Address: 23, Inkerman Way, Huddersfield, HD8 8UU

Application number: 2026/91763	
What is the application for?:	Erection of 40 residential dwellings and associated works
Address of the site or building:	Land off Barnsley Road, Denby Dale, Huddersfield,
Postcode:	LS23 7BA

User comments

SITE LAYOUT PLAN - 2530-SI-02H
BARNESLEY ROAD, DENBY DALE
NEWETT HOMES
SCALE:1:500@A1 - AUGUST 2025

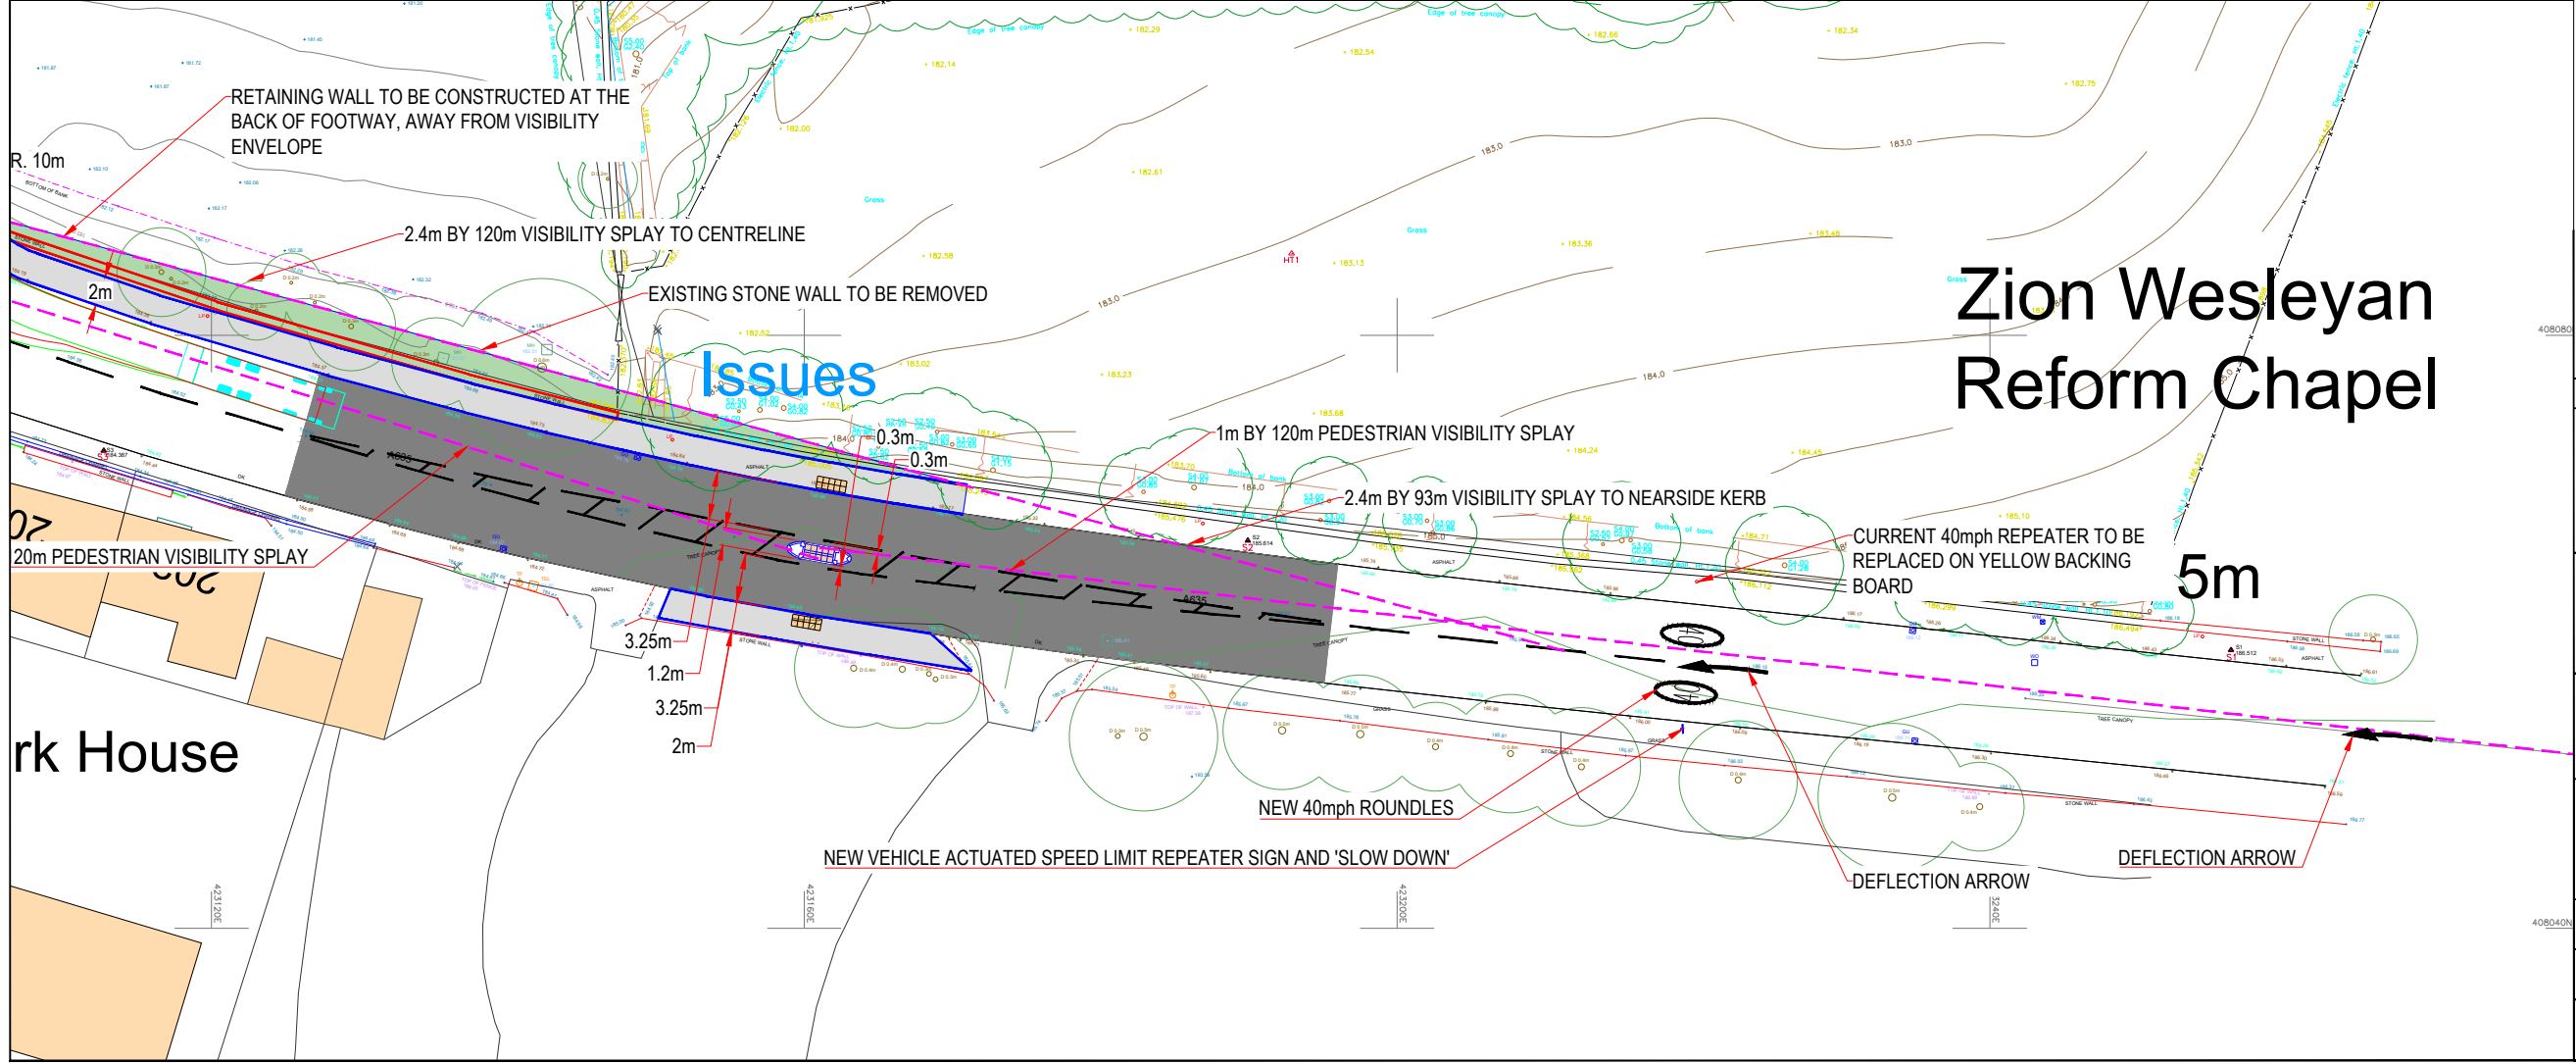
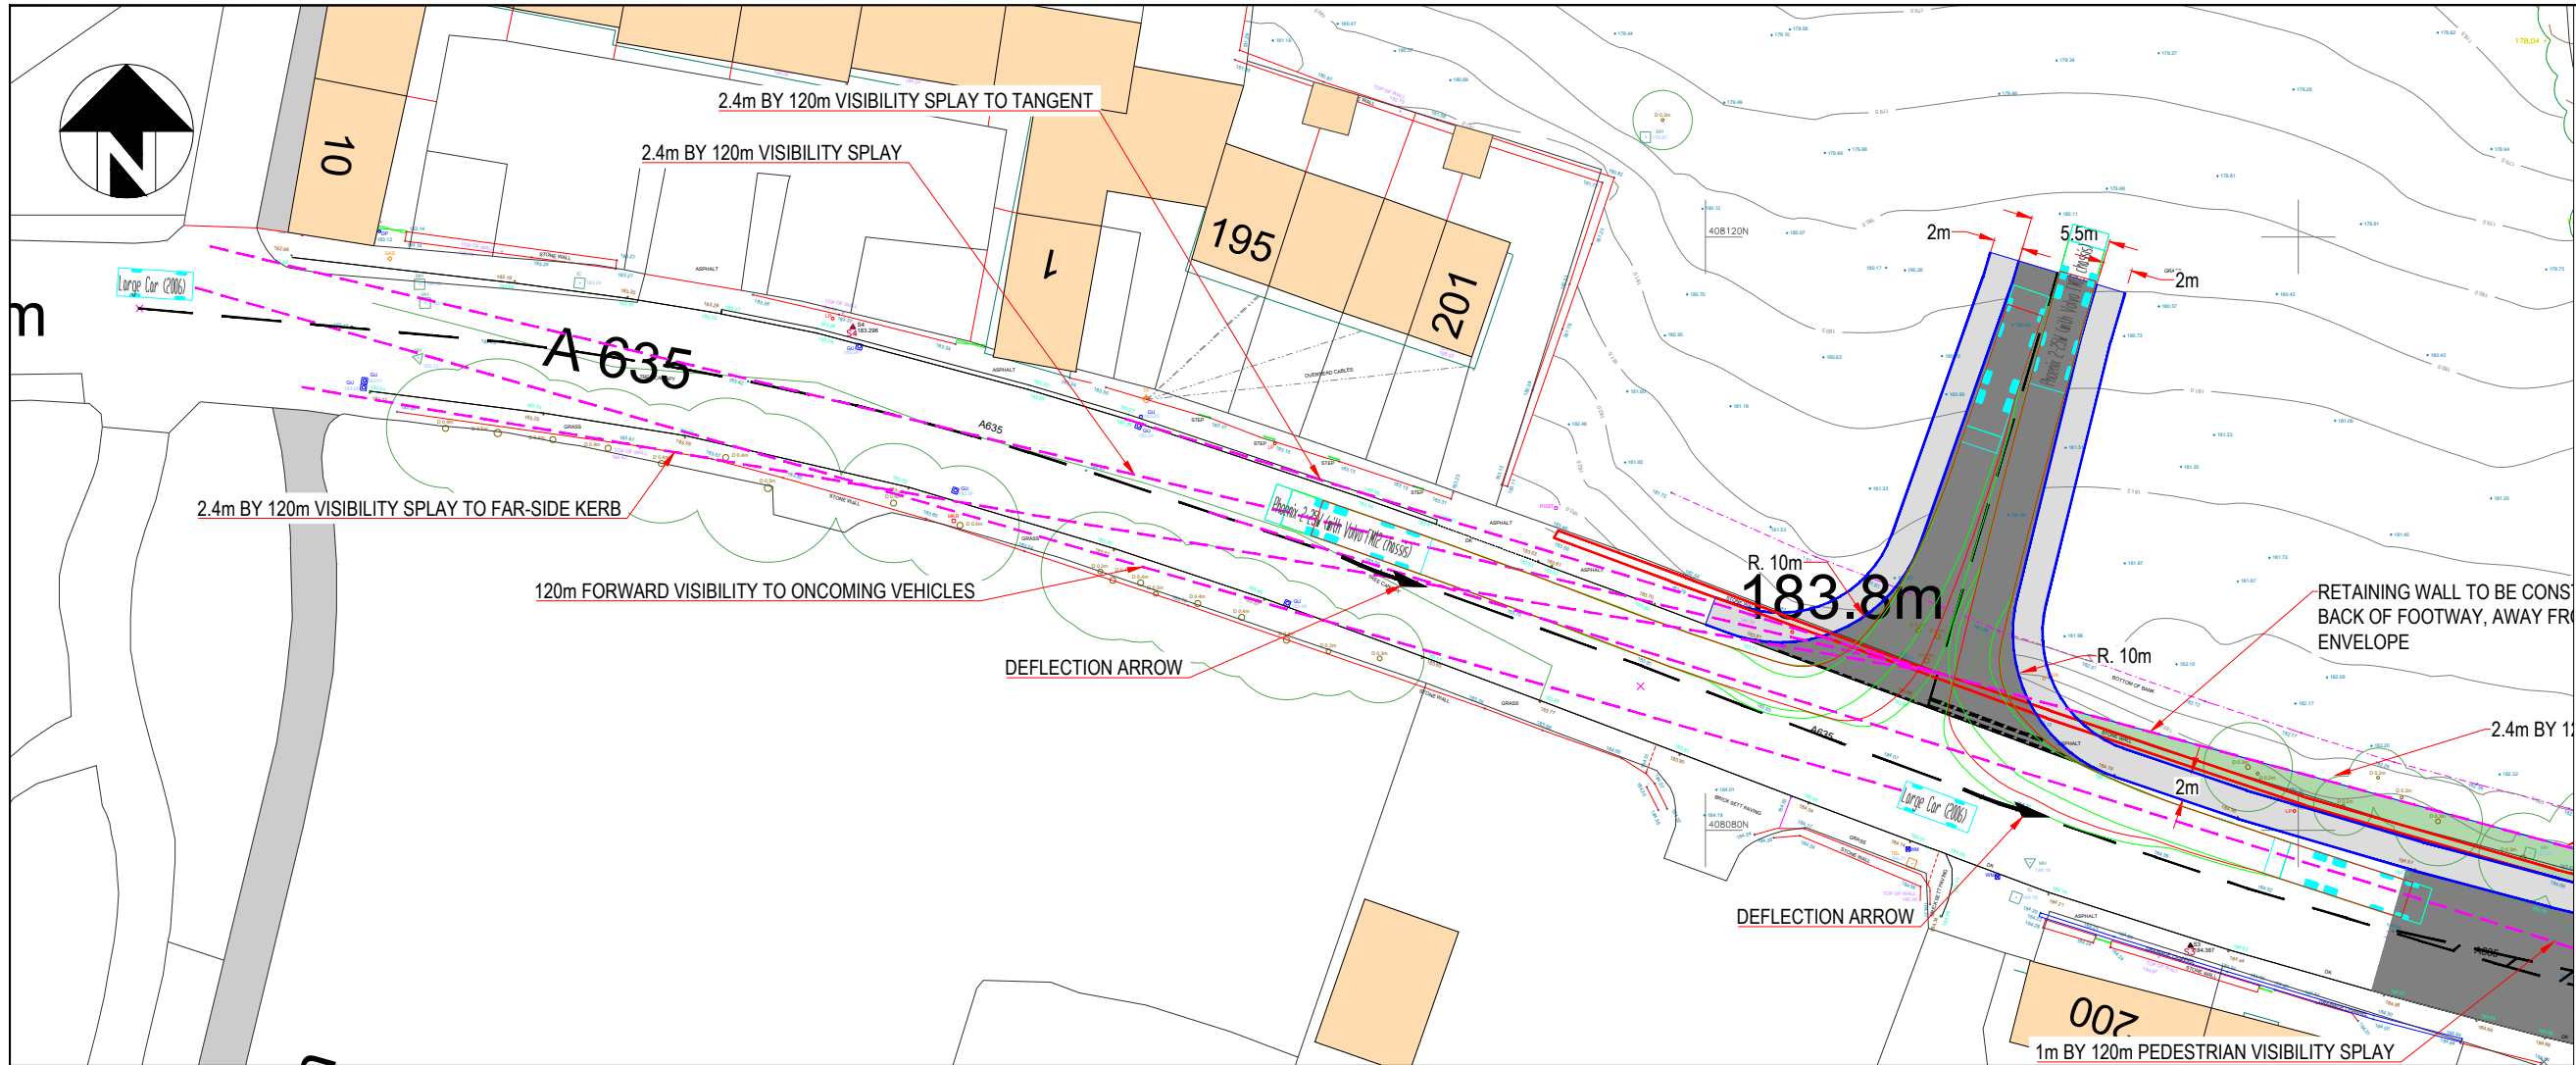
The plot numbered 27 is shown on the plans as 21m separation from my property (23 Inkerman Way). This is the lower limit of the separation distances in the planning guides (Kirklees Housebuilders Design Guide SPD). Plot 27 faces my property directly and the land slopes steeply causing it to overlook living and bedroom areas of my property (see document 2026-91763_ Proposed Site Sections_1151092 - Site Section C-C). In section 7.21 of the Kirklees Housebuilders Design Guide SPD it states - "Longer distances between buildings may be necessary if: Steep topography on the site, which presents challenges relating to overlooking". The plan provides no mitigation for the severe overlook contrary to the guidelines.

In addition, the new development is directly south of my property and owing to the steep slope of the land and proximity of plot 27, there is a significant reduction in natural sunlight. In winter months all direct sunlight will be blocked.

These breaches of the guidelines could be addressed by increasing the separation, reducing the elevation or re-orientation of the houses (so as not to face directly).

The steep topography and underlying geology of the area being developed increase the flood risk to my property. Mitigation has been proposed in the use of a dwarf wall (600mm) and French drains on the northern border directly next to my property. The plan also references a feather edge board (1800mm) on the same border, but it is not clear how this will work along with the dwarf wall. Please clarify.
